Subject: Re: Planning Consultation on: WA/93/20/PL

Re: Planning application WA/93/20/PL: Land East of Tye Lane, Walberton.

Application No:	WA/93/20/PL
Registered:	30th March 2021
Site Address:	Land East of Tye Lane Walberton BN18 0LU
Grid Reference:	497404 106234
Category:	Plan Applicat'n
Description of Works:	Alternative vehicular access off Tye Lane & emergency access off Avisford Park Road, along with minor highway works following WA/95/18/RES. This site is in CIL Zone 2 (Zero Rated) as other development.

AVISFORD PARK ROAD

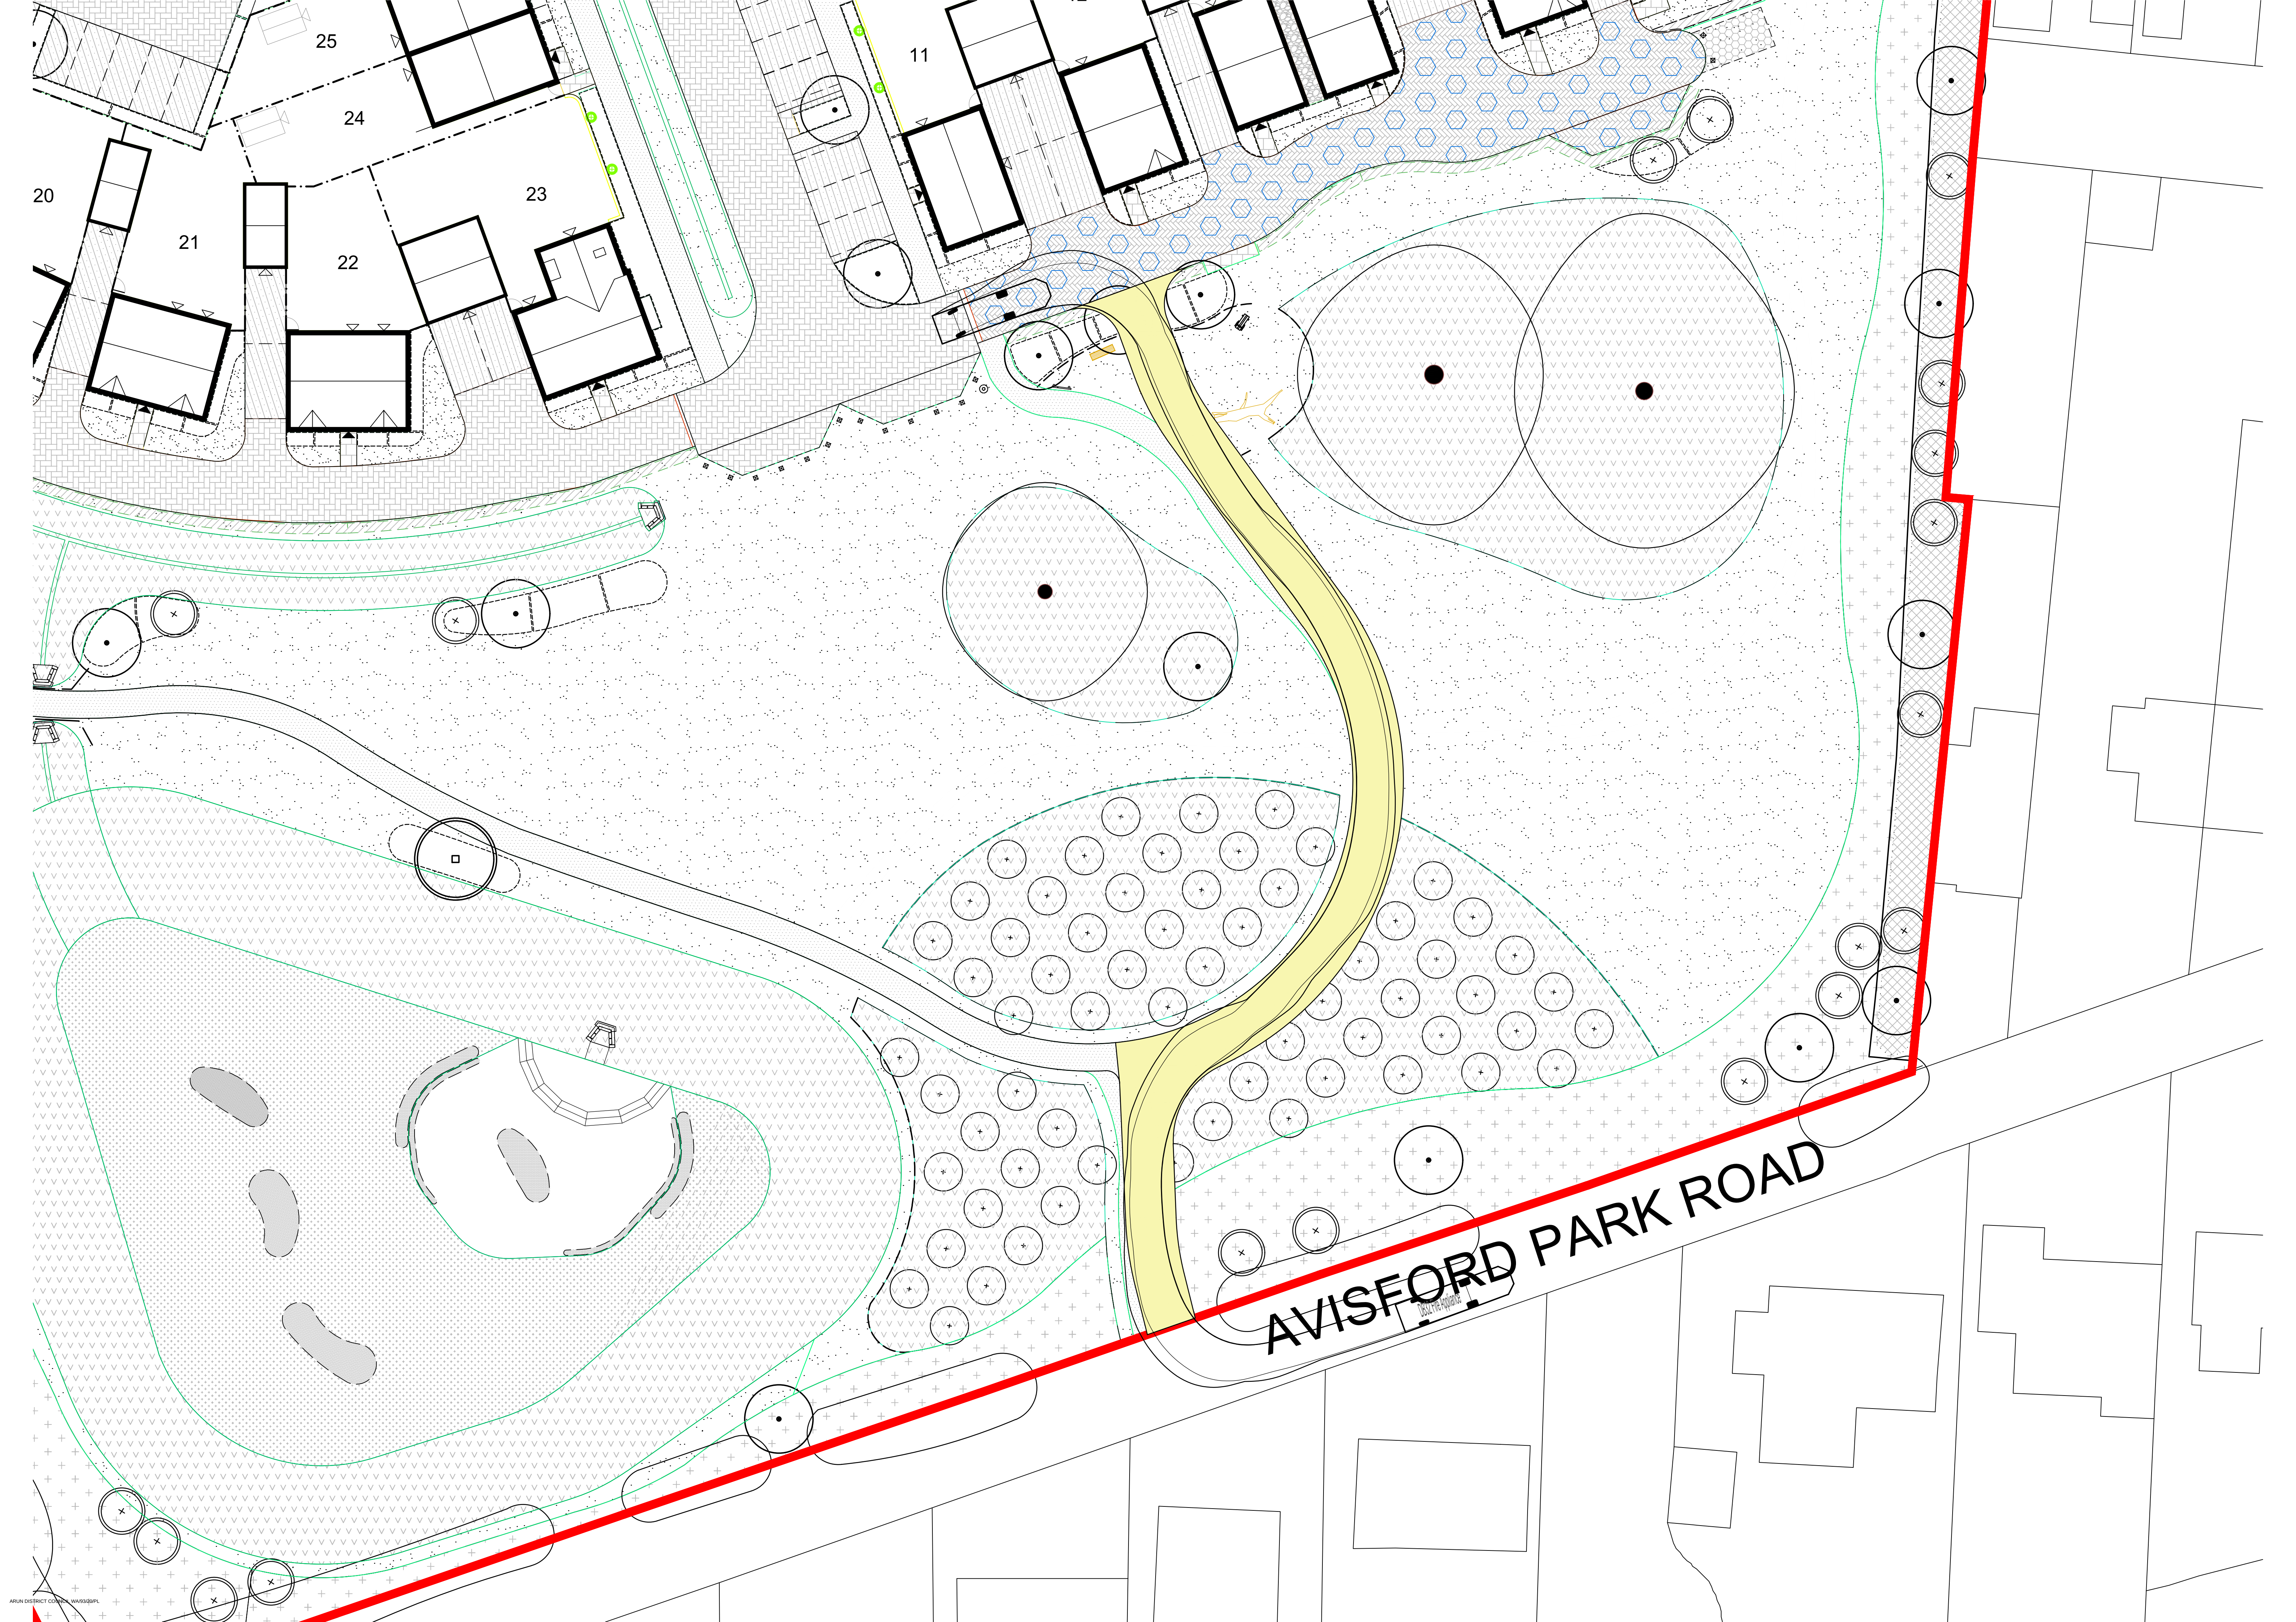
1. The single bollard at each end of the proposed emergency access is insufficient to prevent its use by vehicles such as motor cycles or quad bikes, putting the safety of pedestrians using the public footpath on Avisford Park Road at very high risk, particularly where the proposed emergency access meets the existing public footpath. With a proposed access width of 3.5 metres, it is possible that cars may also attempt unauthorised use as a short cut to and from the Avisford Grange development. An L-chicane should be installed at each end to ensure the safety of all users: this, of course, is incompatible with its use by emergency vehicles.

2. Any widening of the already approved path in order to facilitate use by emergency vehicles is likely to impinge on the (already agreed and approved) public open space and may impact the roots of the three protected trees. Both factors should render the proposal unacceptable.

3. Any additional lighting at the junction of the proposed emergency access with Avisford Park Road should be in accordance with Walberton Neighbourhood Plan Policy VE 8 'Unlit village' status.

4. Removal of established and existing hedgerow to accommodate access from Avisford Park Road would destroy wildlife habitat and nesting sites for birds as well as natural screening of the new development from Avisford Park Road. This is a material change from the approved application, with the existing estate fencing to be replaced with 'like for like'.
